Mr Jeffrey Peng
NSW Department of Planning, Housing and Infrastructure
jeffrey.peng@dpie.nsw.gov.au

Sunday 17 May 2026

Objection to proposed modification 4 of Emirates Wolgan Valley Resort (MP06_0310)

Figure 3.2 Site Plan of Homestead Complex

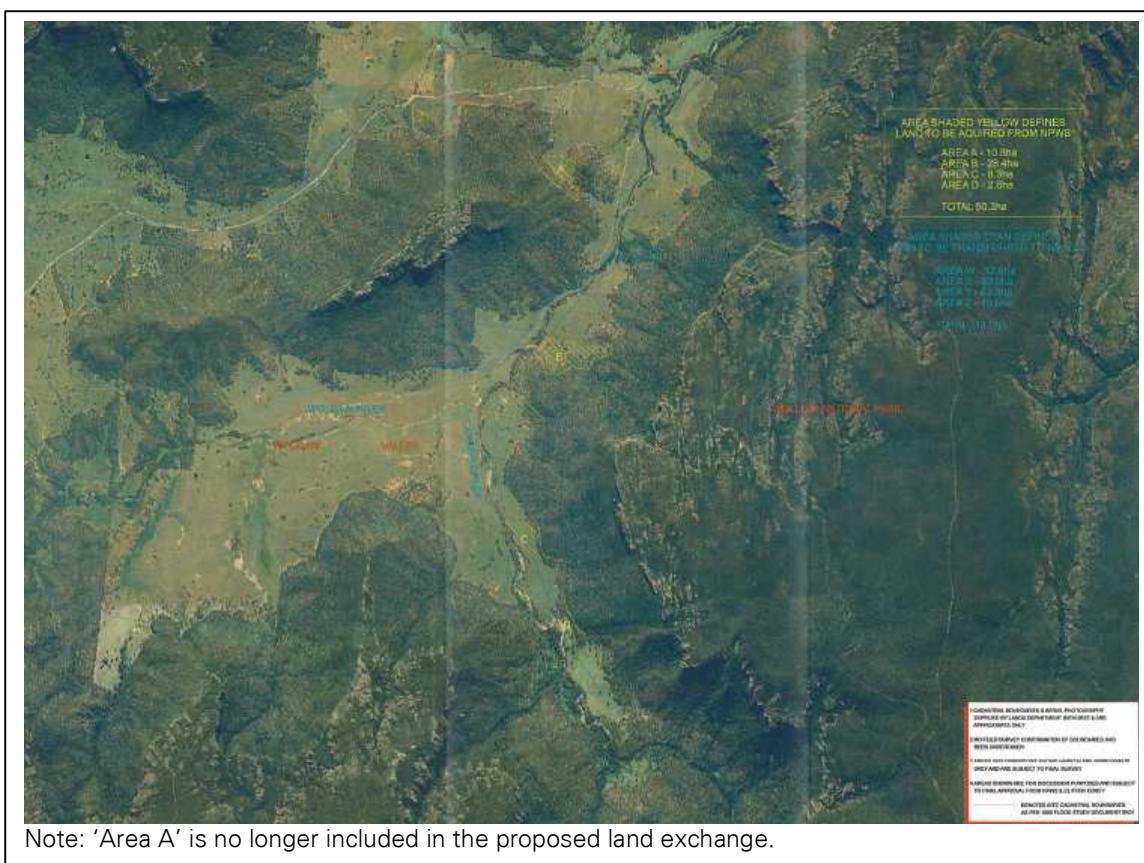
The applicant has failed to meet critical environmental obligations of the development consent. The resort was originally permitted to occupy part of the Wollemi National Park based on a land exchange agreement. According to Figure 2 of the Modification Report, these exchanges have not been delivered.

Figure 3. Preferred flight paths.

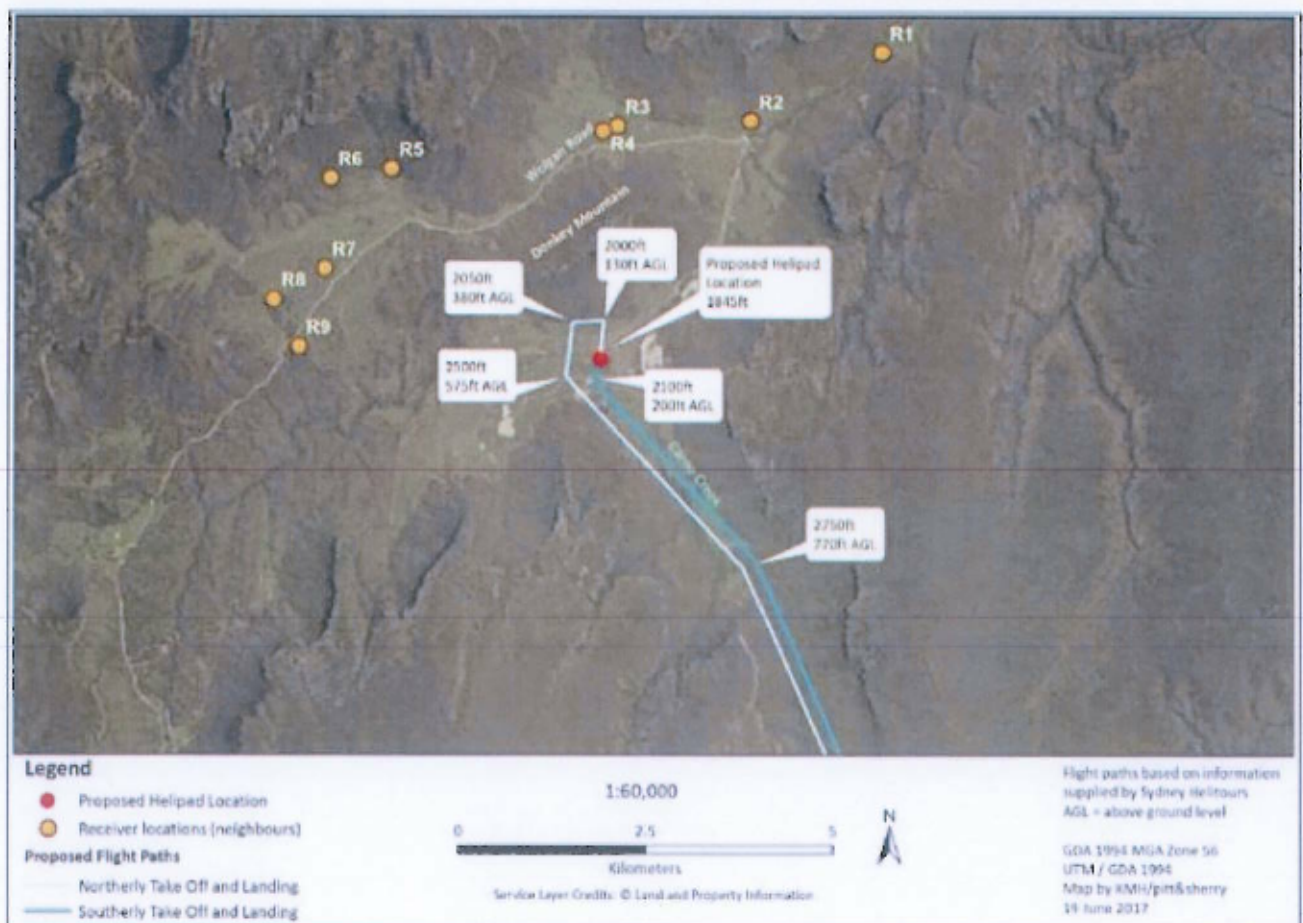
The revised flight path over Newnes Plateau passes directly over a NPWS public campground (under construction, but nearly completed) and the Gardens of Stone Pagoda Walk. It will ruin the acoustic amenity in Forest Camp, the Birds Rock Lookout and the Bird Rock Precinct, as well in Acoustic Canyon, which is near the Wolgan Valley escarpment and has outstanding geodiversity features. Furthermore, the NPWS is currently constructing high-standard walking tracks and proposing commercial tourist accommodation in the Carne Creek catchment. These 'bush luxury' experiences—and the public campsites—will be significantly degraded by helicopter noise, likely resulting in negative social media coverage and a decrease in returns on the NSW Government's \$50 million capital investment in visitor facilities.

Reference to the Fly Neighbourly Agreement (FNA) is insufficient as it has not been updated to include the Gardens of Stone SCA. Furthermore, the claim that operations will be 'inaudible or only barely audible' contradicts the experience of park visitors. Figure 9 of the Modification Report apparently fails to model noise at the elevation of Birds Rock Lookout (1,181 m), which will be overflowed at a lower level than the model apparently estimate as it does not seem to fully account for this specific terrain detail.
